The Yorkshire and Humber (CCS Cross Country Pipeline) Development Consent Order

Application for the Yorkshire and Humber Carbon Capture and Storage (CCS) Cross Country Pipeline Development Consent Order (Reference: EN070001)

1. Drax PIG Trap Drawings (Document 2.18, 2.19, 2.20 and 2.22 Rev C)

**DRAX PIG TRAP  
PLANNING ARRANGEMENT**

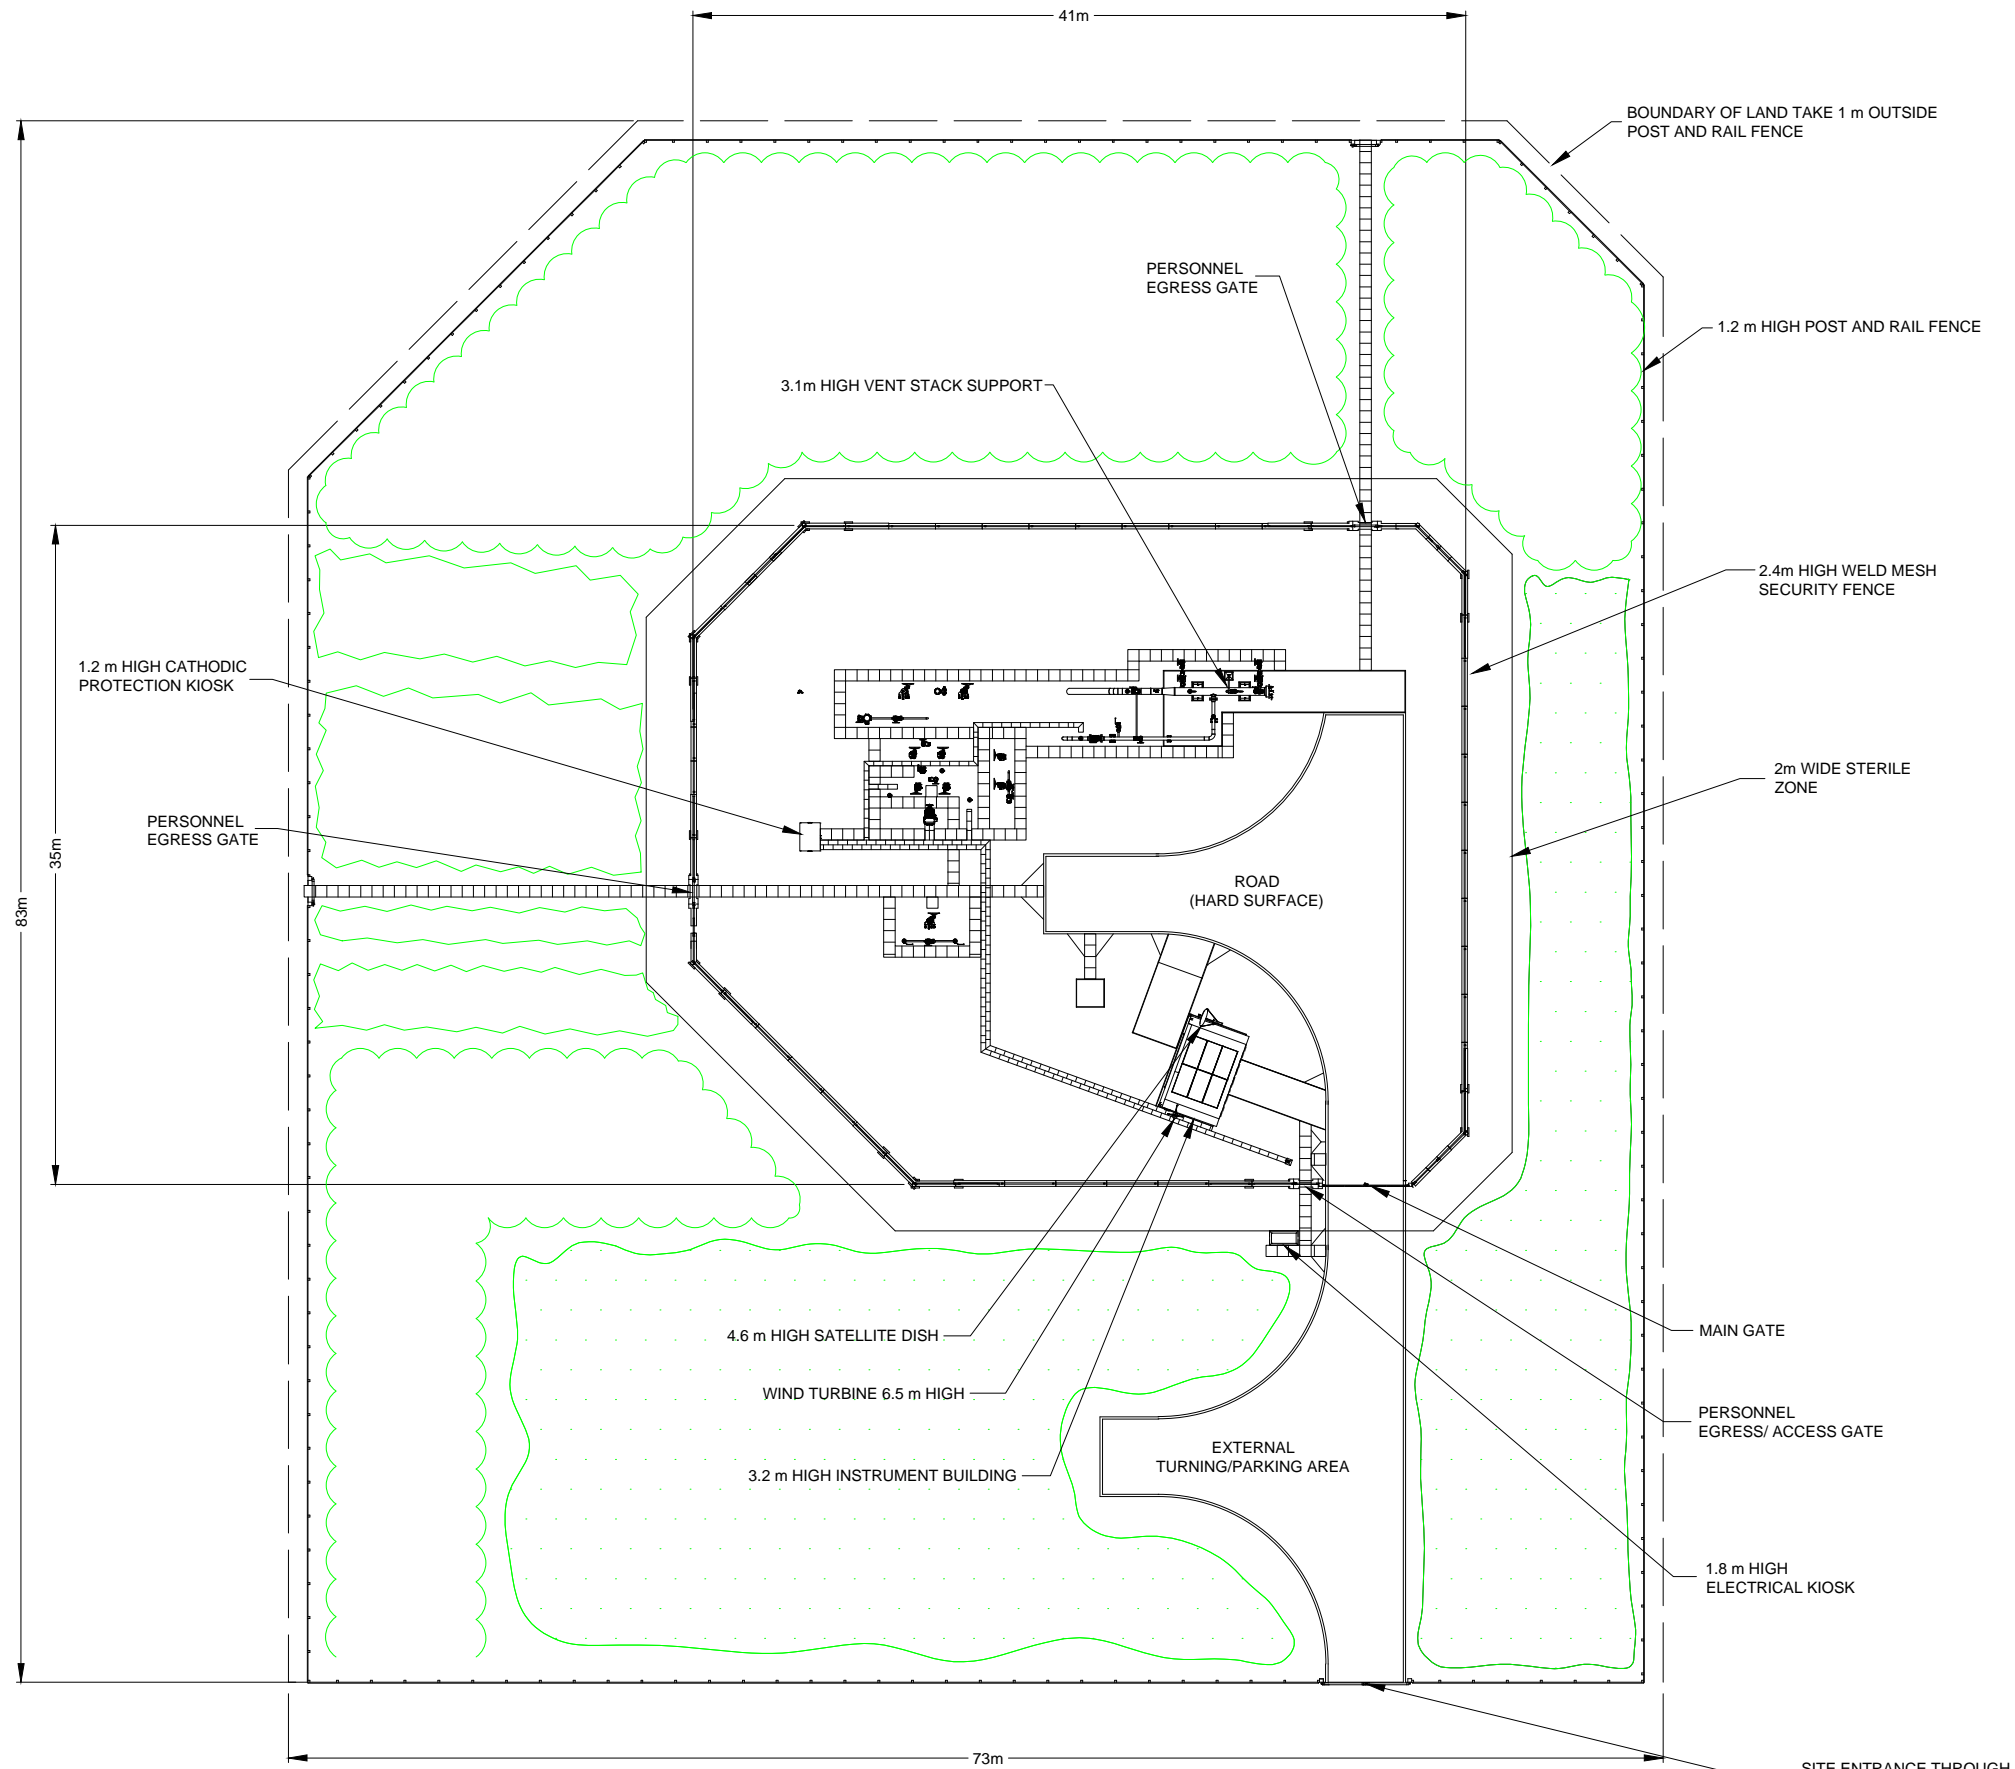
As advised in in document 14.1, page 5, submitted by National Grid at Deadline 5, updated Drax PIG Trap plans are included (Document References 2.18, 2.19, 2.20 and 2.22) reinstating the height of the security fence to 2.4 metres. Approved Plans Schedule 2 Part 4 and Part 6 of Revision F of the draft DCO has also been updated to reflect this position
